Review of GTA's (Traffic, Transport and Access Impact Assessment) (Issued 25/11/2015) with regards to UNSW interests.

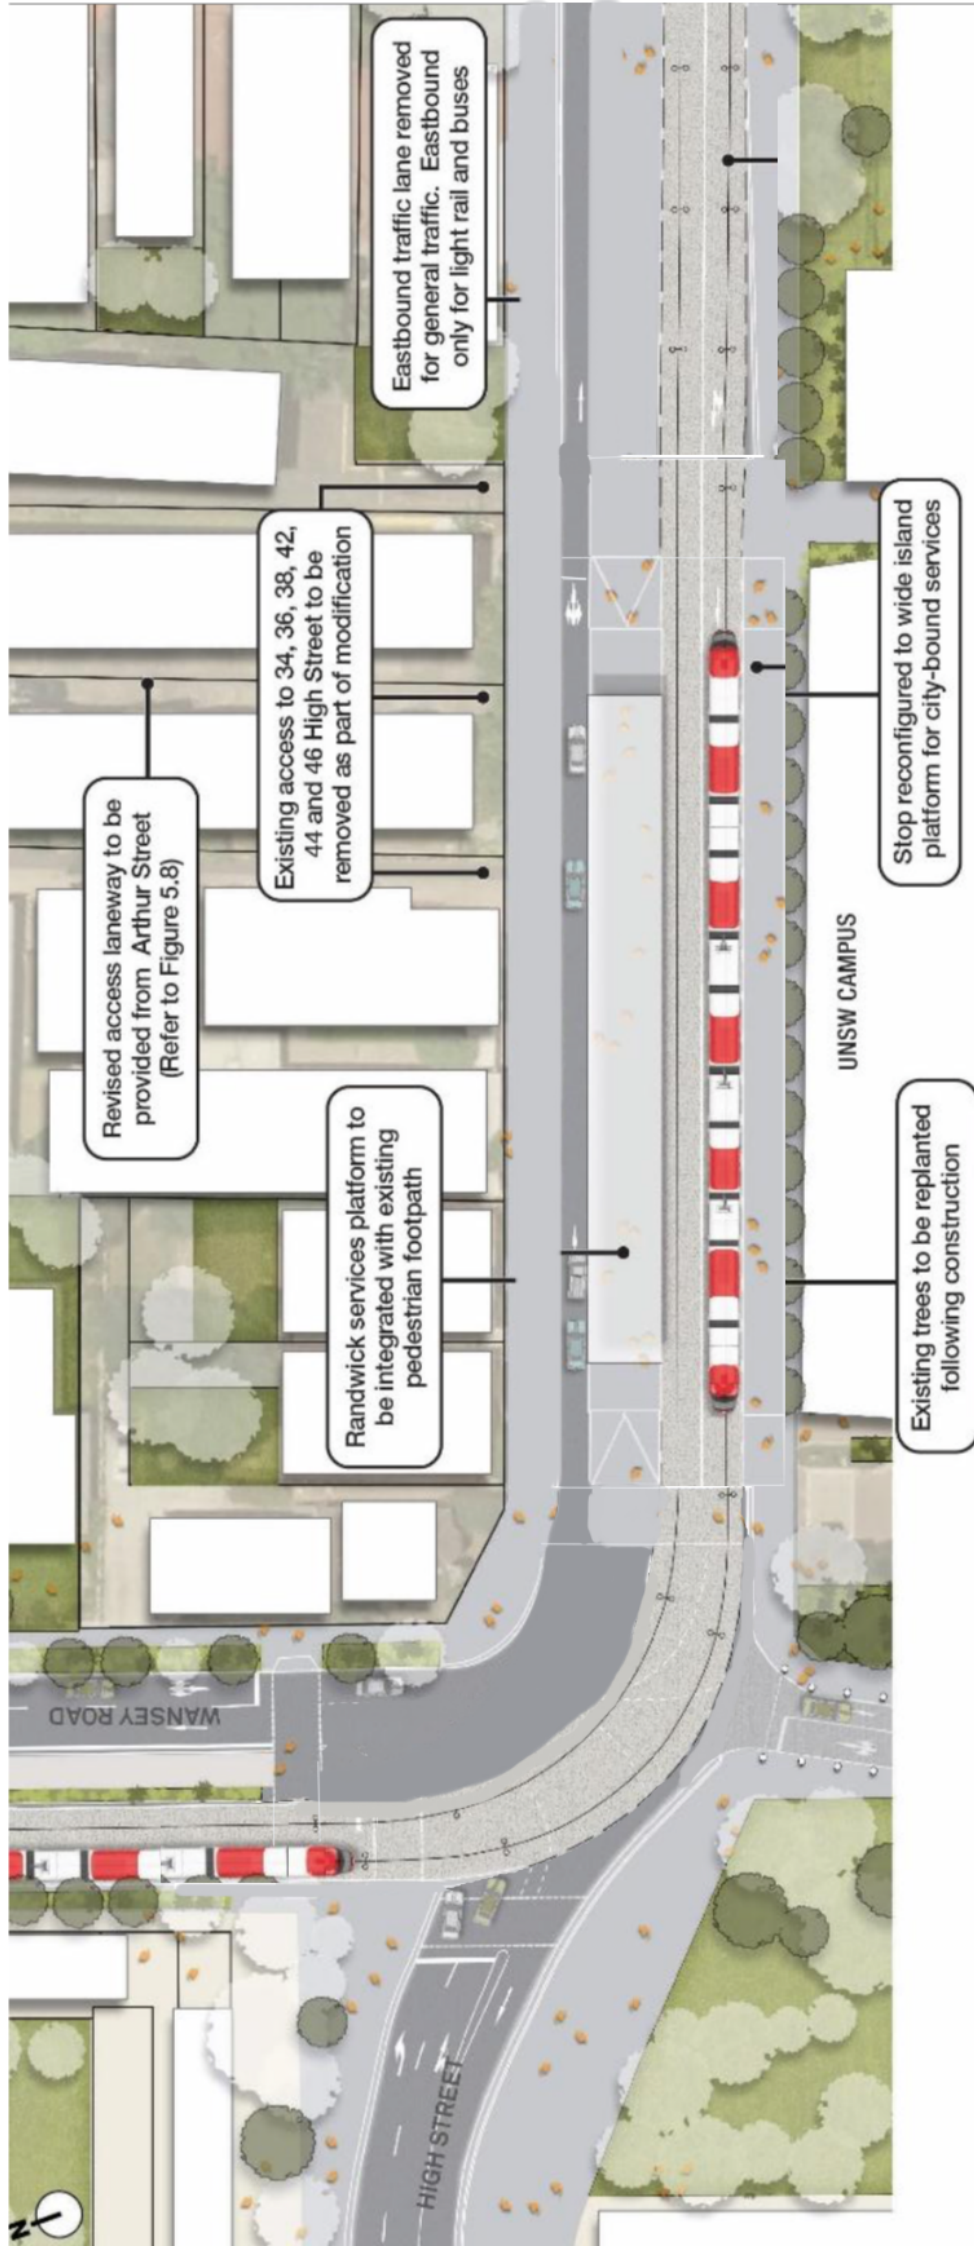
Page	Item	Summary of Issues / Actions
26	<p>Section 3.4.3 Arthur / Botany – agree that traffic signals should be provided. However, no detail provided on Figure 3.7 as to the arrangement on Arthur Street west of Botany Street. This may need to be used as the bicycle connection.</p> 	<p>TfNSW to provide further detail of layout for Arthur Street between Wansey Road and Botany Street, in particular for cyclists.</p>
34	<p>Section 3.6.1 Arthur Street laneway – generally looks ok, need to confirm design vehicle (usually garbage truck, fire truck).</p> 	<p>TfNSW and Council to confirm design vehicle for Arthur Street laneway.</p>
37	<p>Section 4.1.1 Stop accessibility – no detail provided regarding signal phasing ‘length of signal phase time required’. Need to remember that no impact on eastbound traffic when pedestrians crossing.</p>	<p>TfNSW to provide details regarding intersection operation. Effect on westbound traffic would be similar to central island stop i.e. all passengers cross westbound traffic lane.</p>

39 & 40	<p>Figure 4.1 and 4.2 – significant decrease on High Street, major increase on Arthur Street and Belmore Road. Largest impact will be Arthur Street – this is likely to be main area of community opposition (local residents).</p> <p>‘Figure 4.1 and Figure 4.2 also show that in the modified Project scenario, Arthur Street and Alison Road become the primary routes for diverted trips, and to a certain extent, Barker Street and Botany Street south of High Street in the AM peak.</p> 	<p>Note.</p>
46	<p>Section 4.2.5 Figure 4.7 and 4.8</p> <p>Changes in intersection operation – there is major benefit to Anzac Parade at High Street. This will benefit LRV along Anzac Parade. There is an increase in average delay at the Wansey Road/High Street intersection.</p> 	<p>Note.</p>

TfNSW requested to further consider the closure of High Street westbound between Botany Street and Wansey Road.

TfNSW requested to model the closure of the westbound traffic lane on High Street between Botany Street and Wansey Road to assess the potential impacts.
